RE: A556 Link Road

I am a resident of High Legh near Knutsford , I am extremely concerned about the A556 Link Road and wish to be registered as an interested party.

Cuttings and embankments

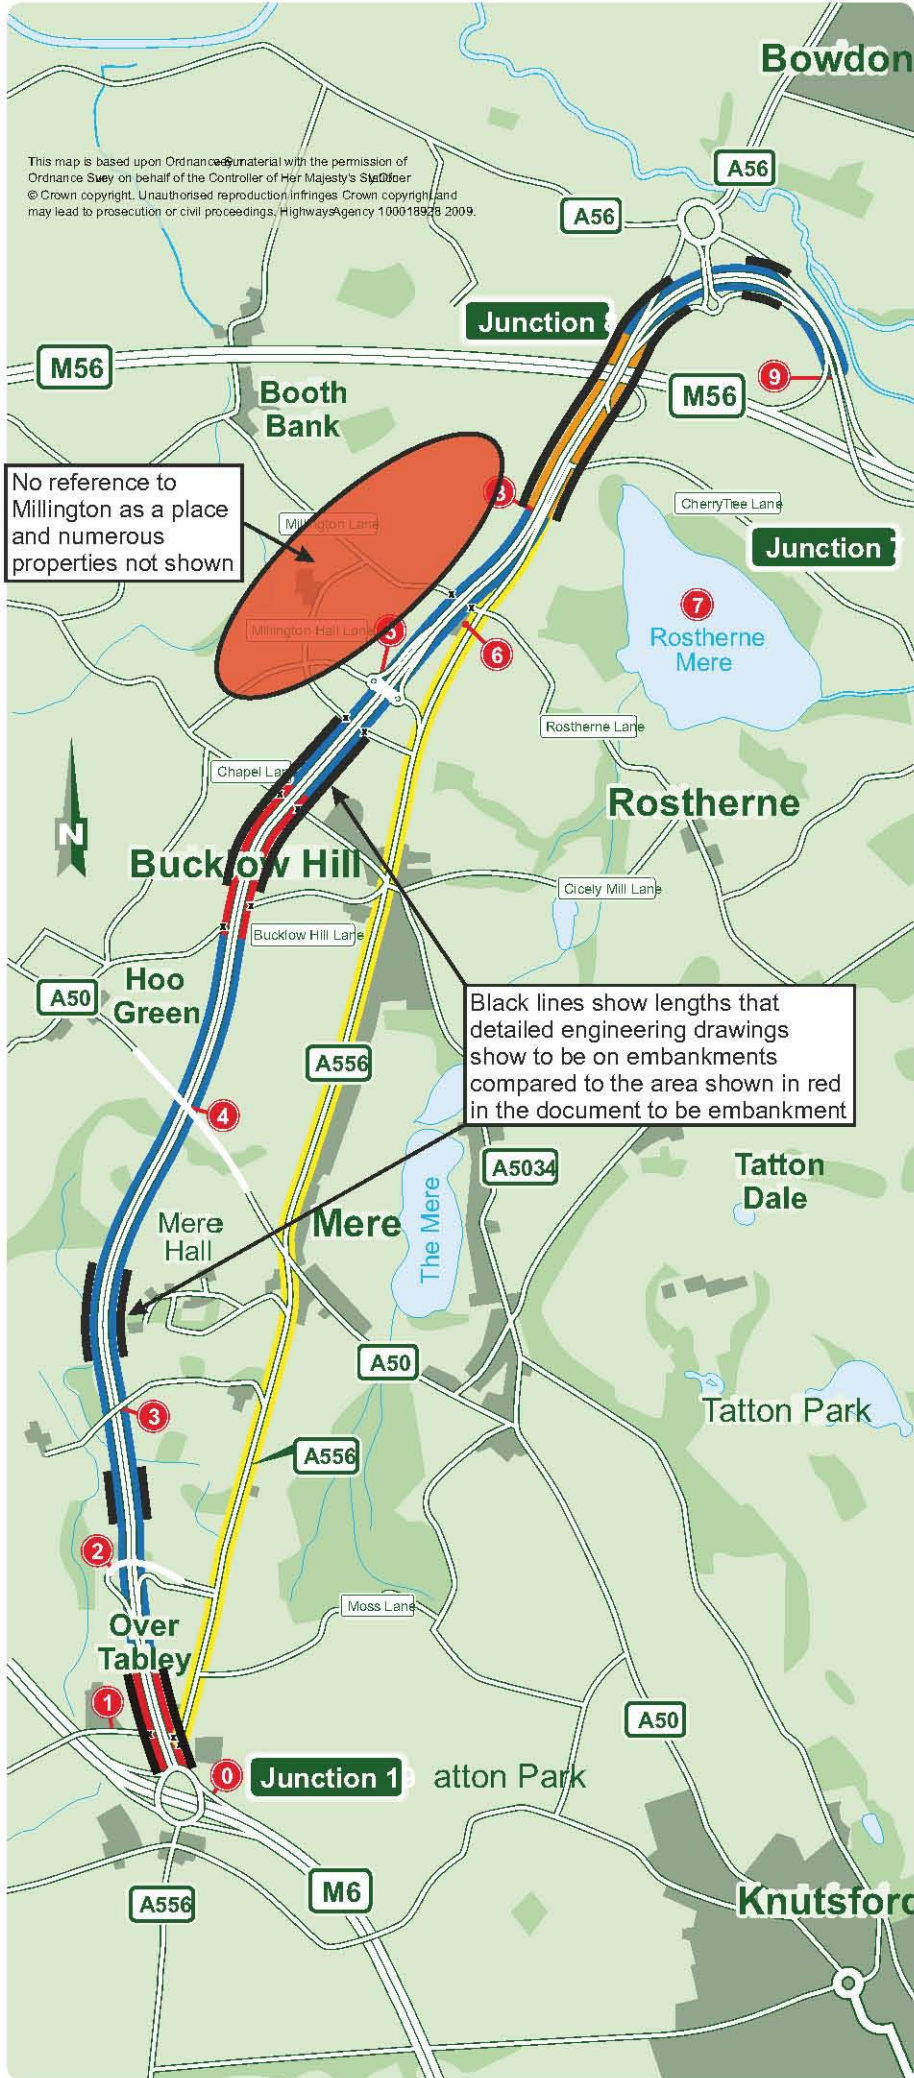
- The Summary Document (SD) is, at best, **extremely misleading** in several respects; diagrams illustrate all Mere properties but do not acknowledge the homes to the West of the road; The maps at the Public Exhibition confirm that cuttings to be provided along the majority of the route (promised in 2007), which appear in the SD diagrams, will actually **not** be provided after all, despite the HA's assurances to the public that they intend to "minimise the environmental impacts of the scheme"; Non-locals are being asked to complete a questionnaire based on **flawed** and misleading information, believing the scheme to have little or no impact since there appears to be little more than empty fields to the West of the road. **The public cannot possibly make an informed decision** and therefore IPC cannot consider the results of the questionnaires.
